Flood Management & Drainage Consultation - LEAD LOCAL FLOOD AUTHORITY – Statutory Consultee

Consultation on Application Number: 2017/94019

Address: Land off, St Mary's Avenue, Netherthong, Holmfirth, HD9 3XN

**Proposal: Discharge conditions 4, 7, 9, 11, 12, 13 on previous permission
2014/91533 for outline application for erection of residential development**

- ALL ADAPTABLE SEWER WORKS AND MATERIAL TO BE IN ACCORDANCE WITH SEWERS FOR ADOPTION 6TH EDITION THE RELEVANT BRITISH /EUROPEAN AND YORKSHIRE WATER'S STANDARDS/REQUIREMENTS /ADDENDUM AND KITEMARKED.

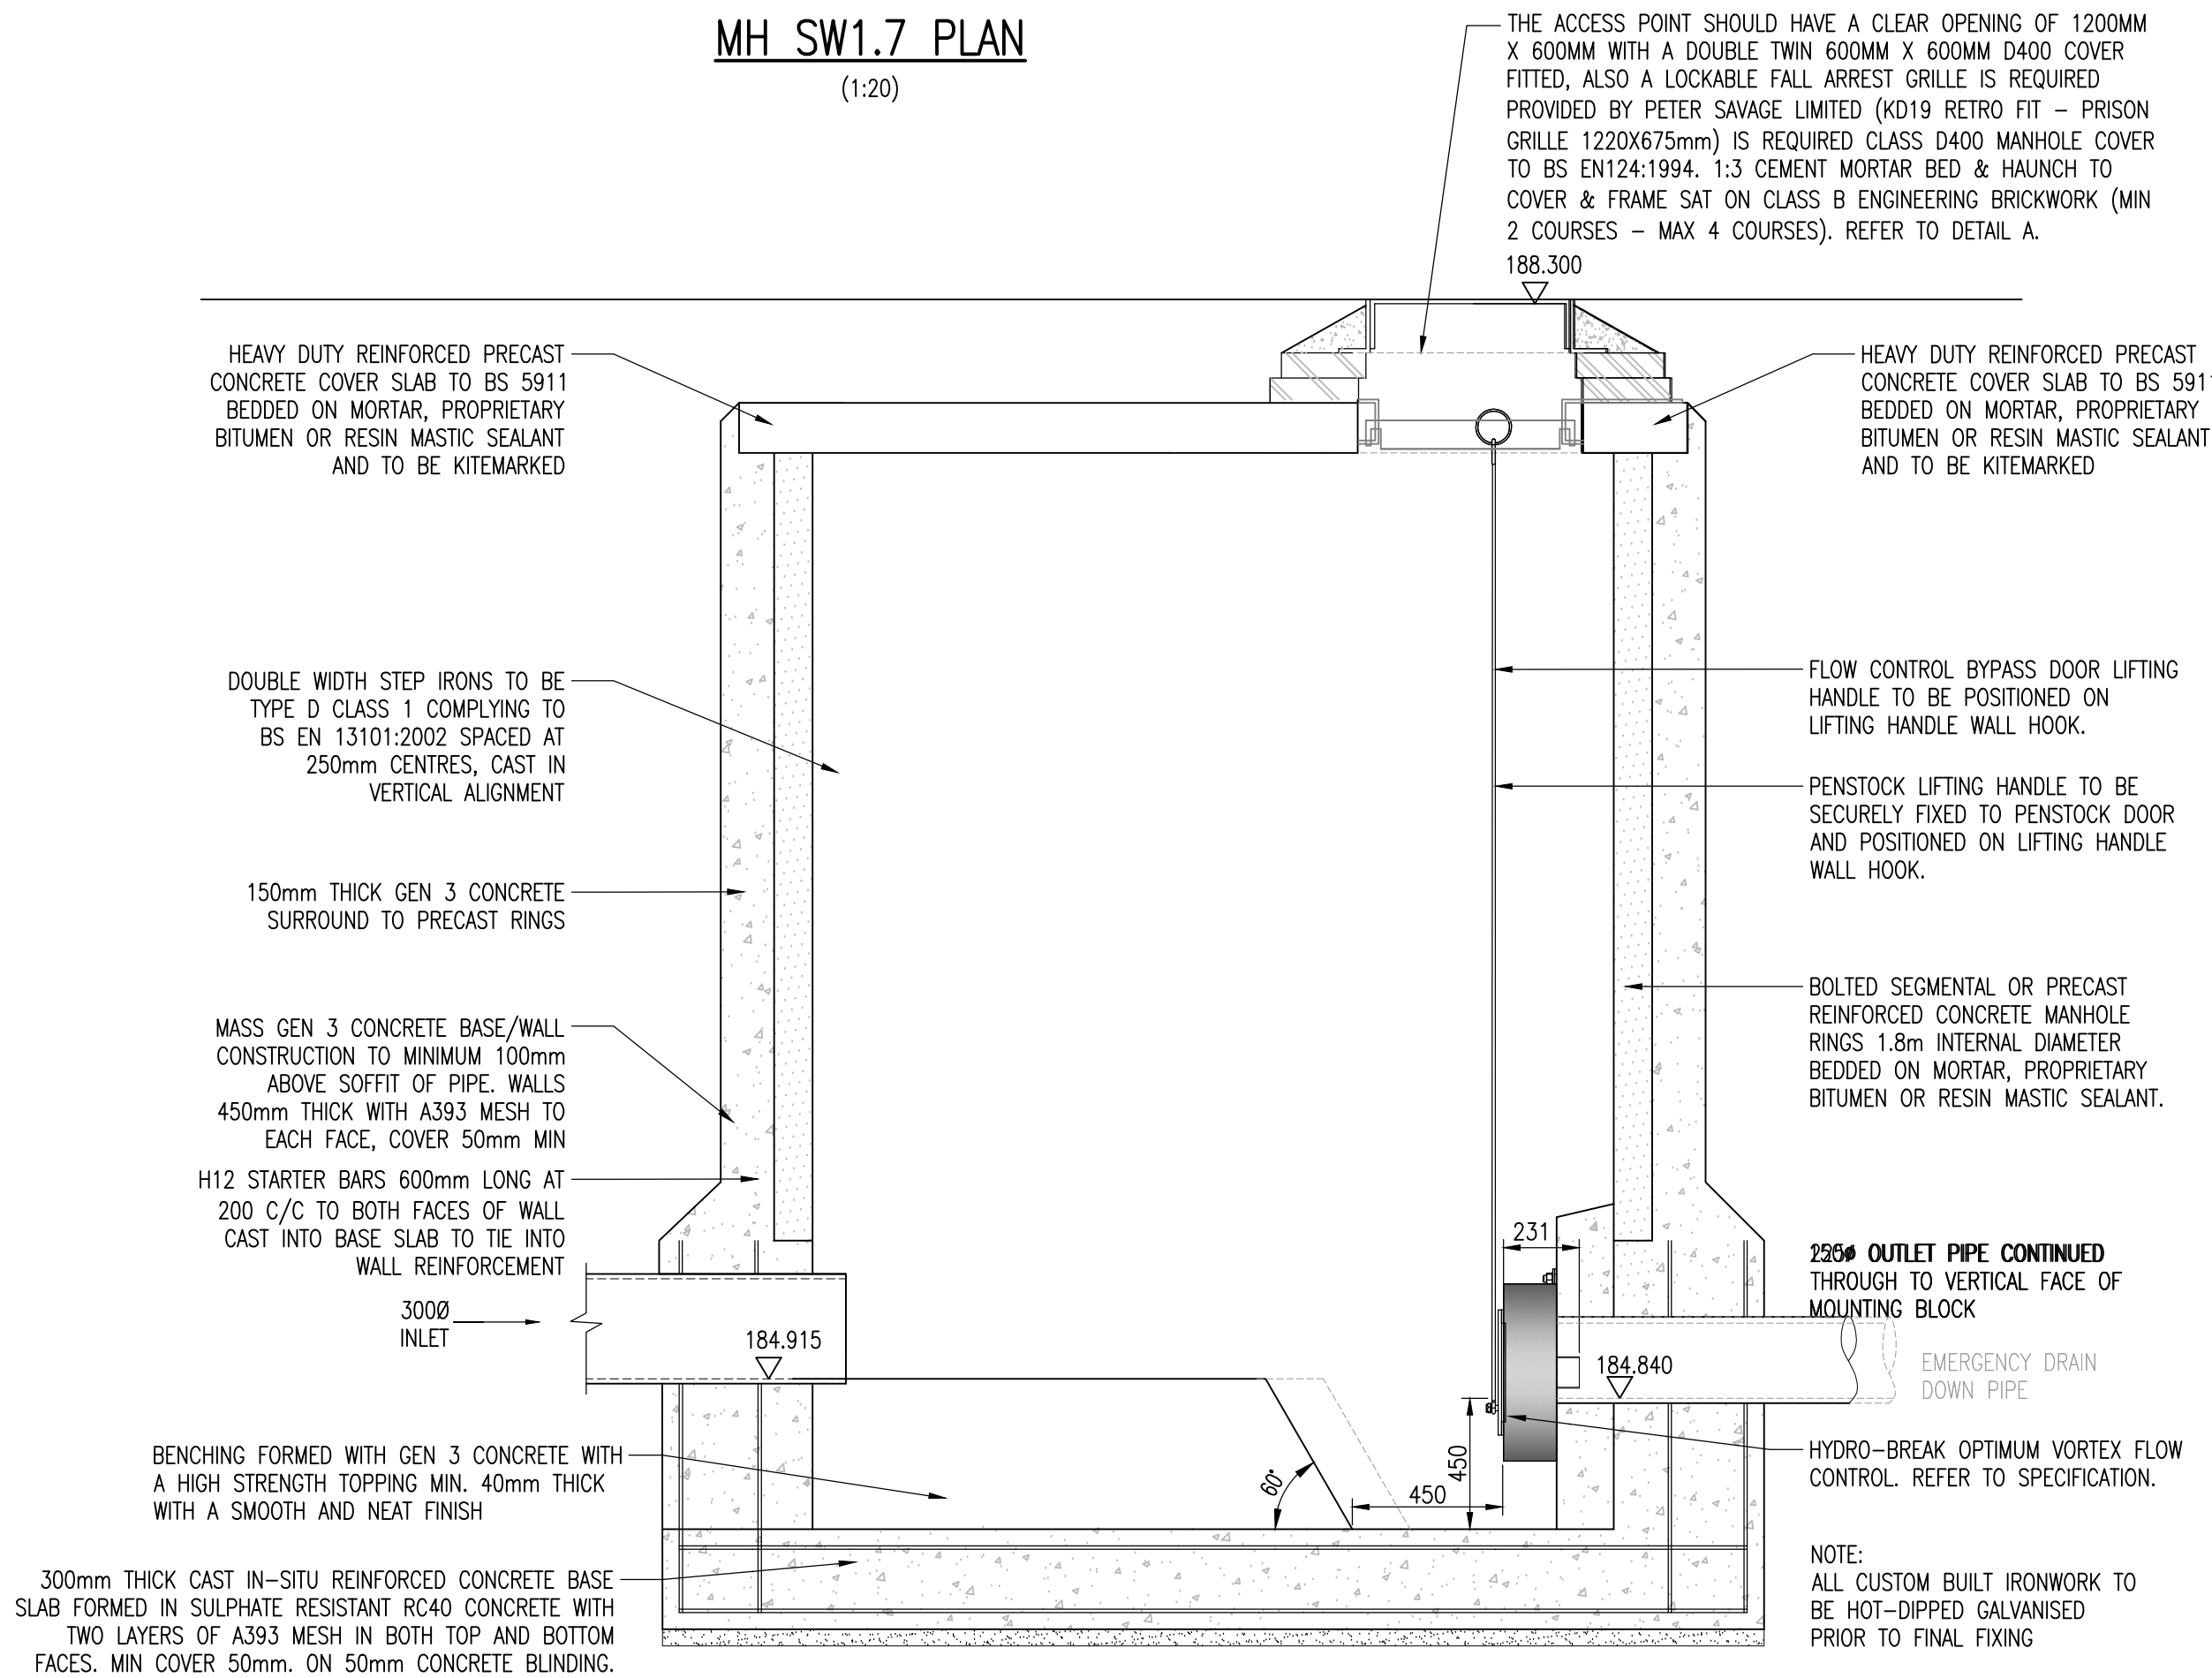
The attenuation submitted is shown not to flood in the 1 in 100+ climate change event.

Project
**ST MARY'S AVE,
NETHERTHONG,
JONES HOMES**
Title
PROPOSED OUTFALL PLAN

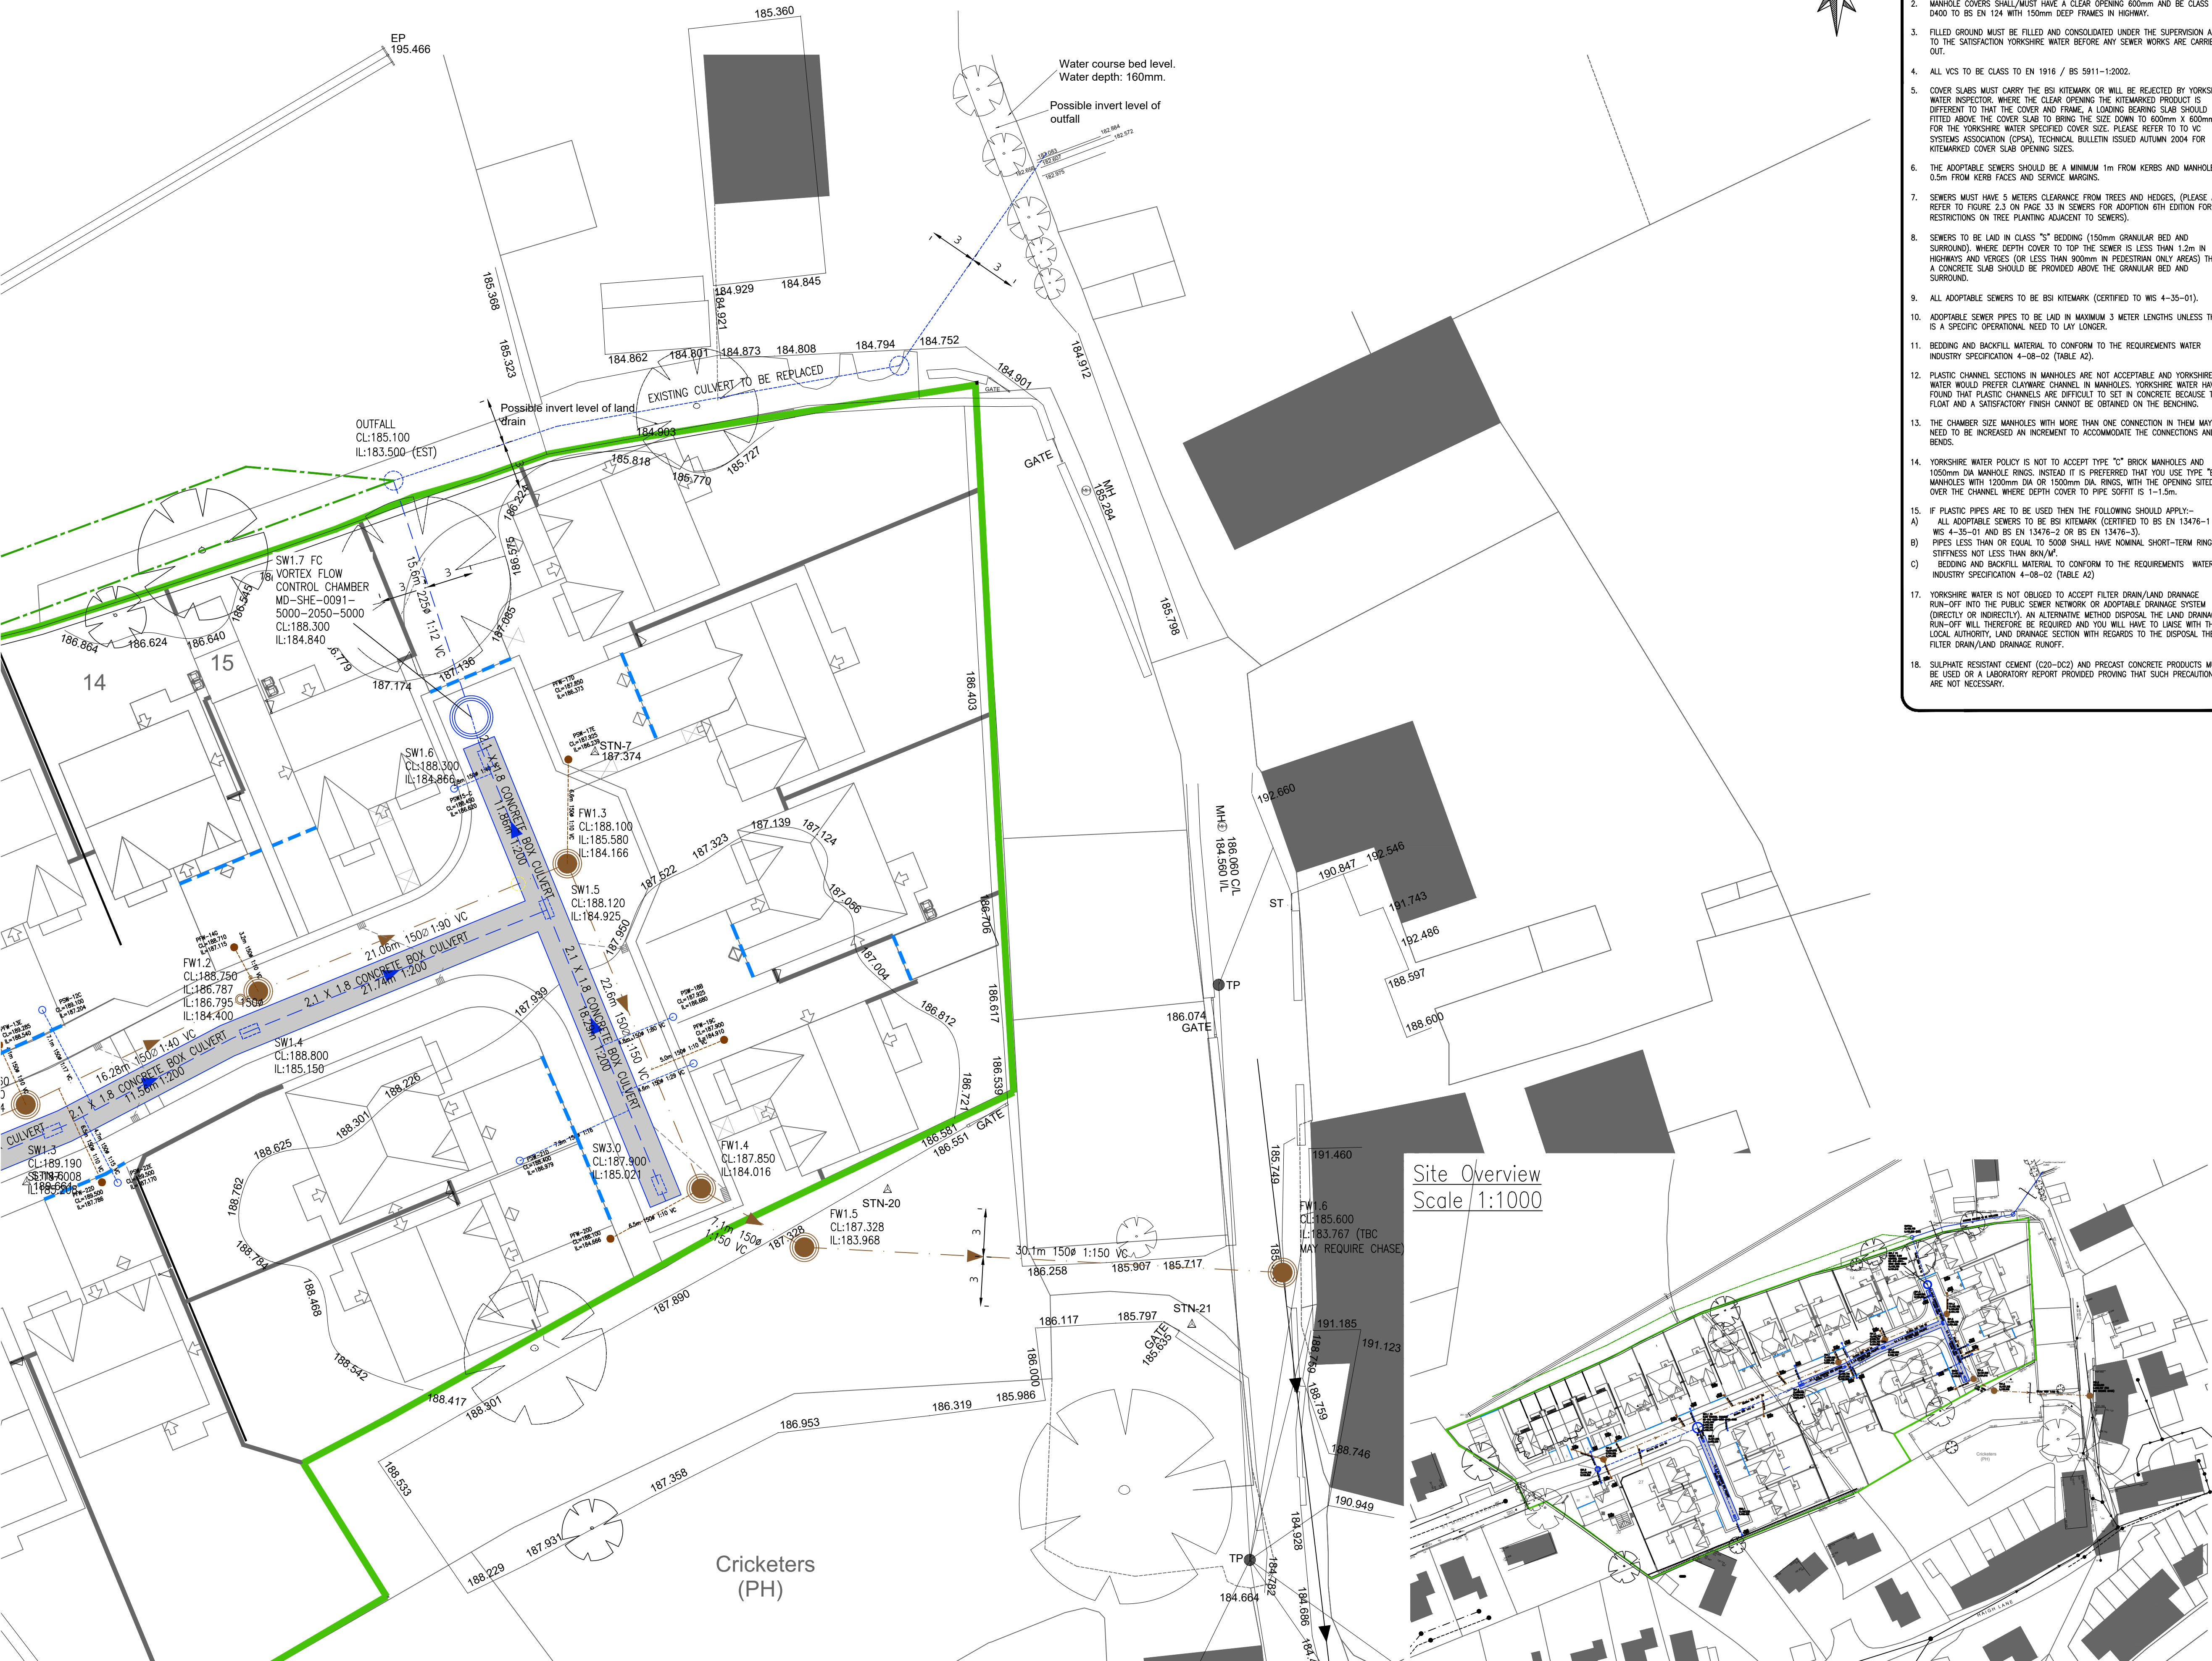
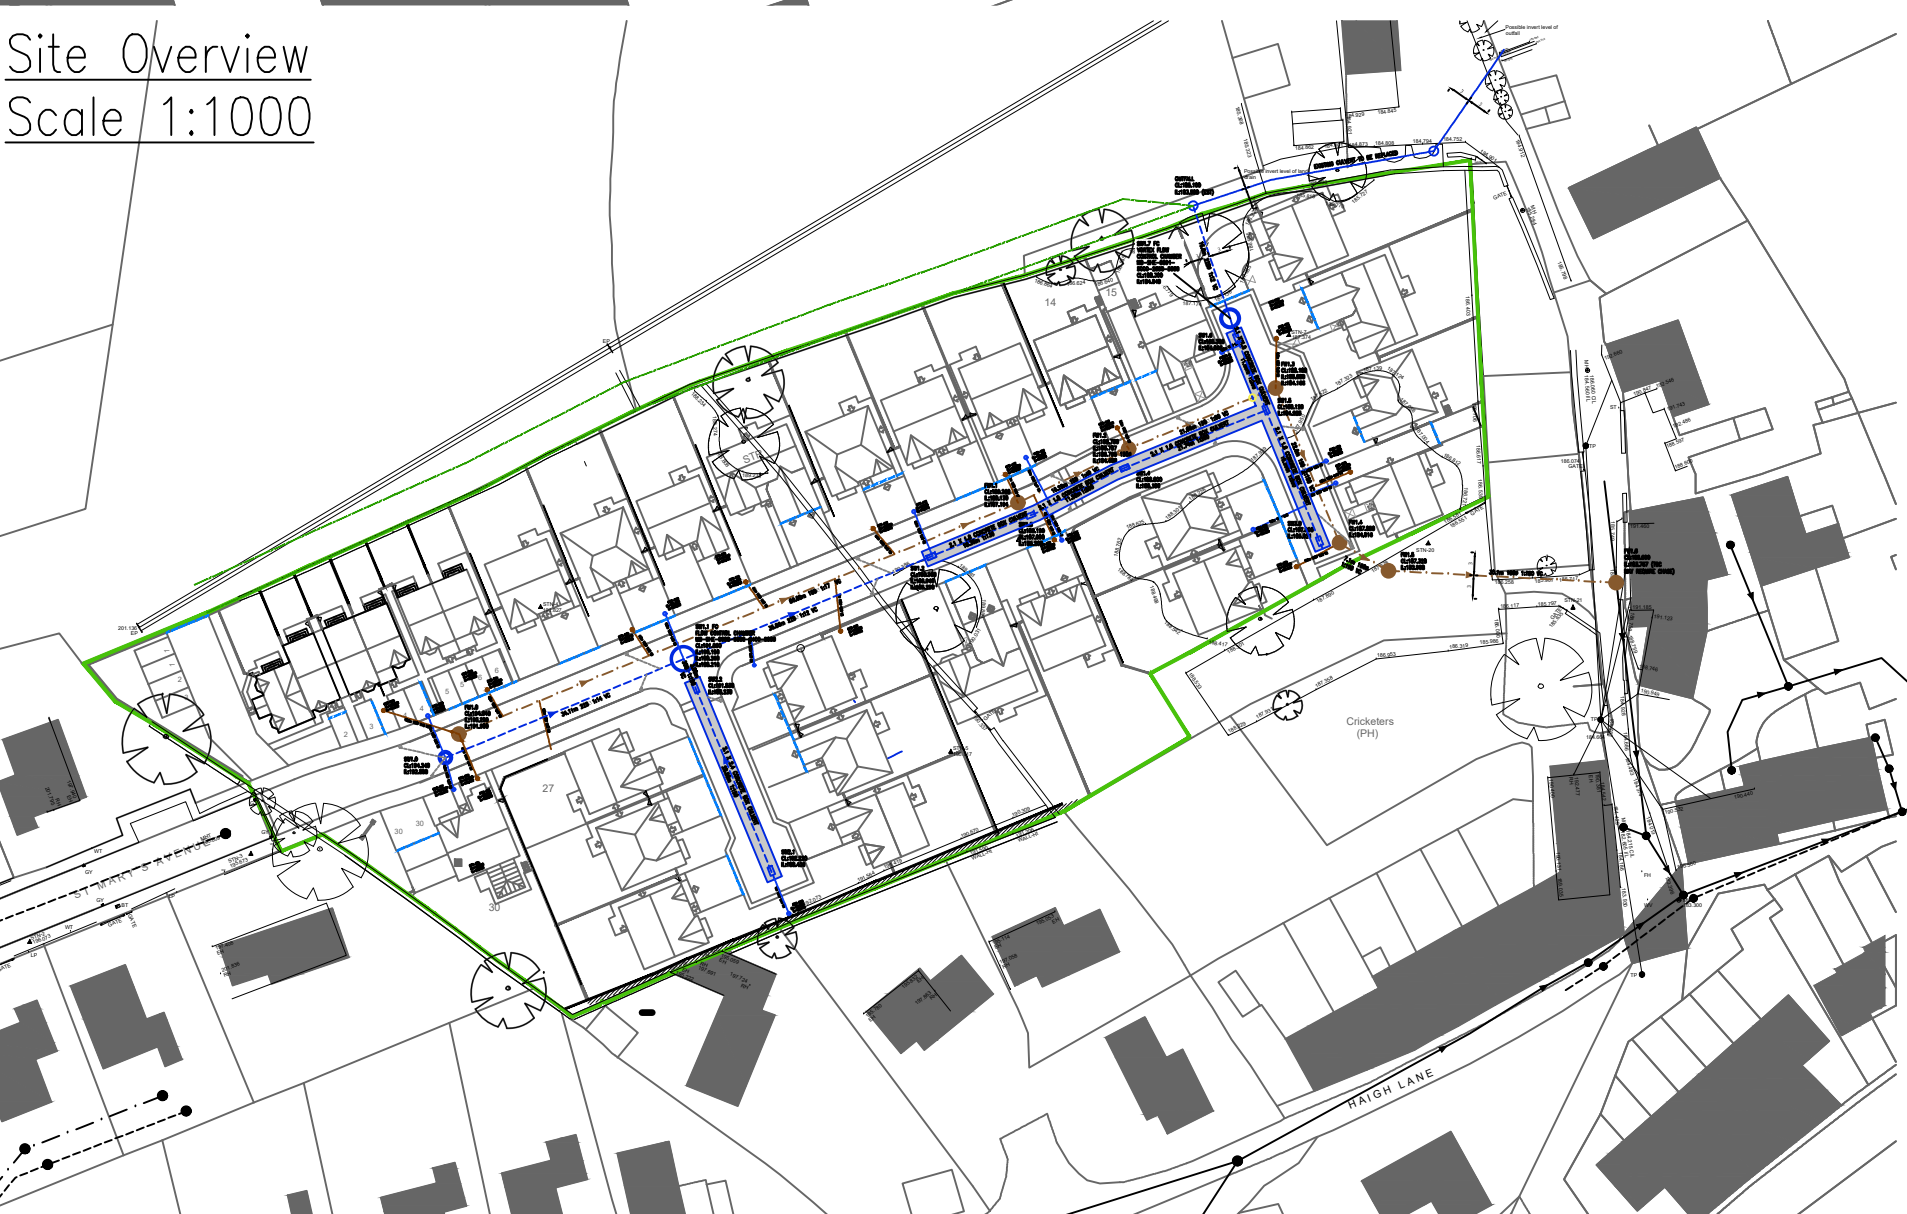
The drainage layout scheme shows a connection to watercourse at an appropriate rate and route.
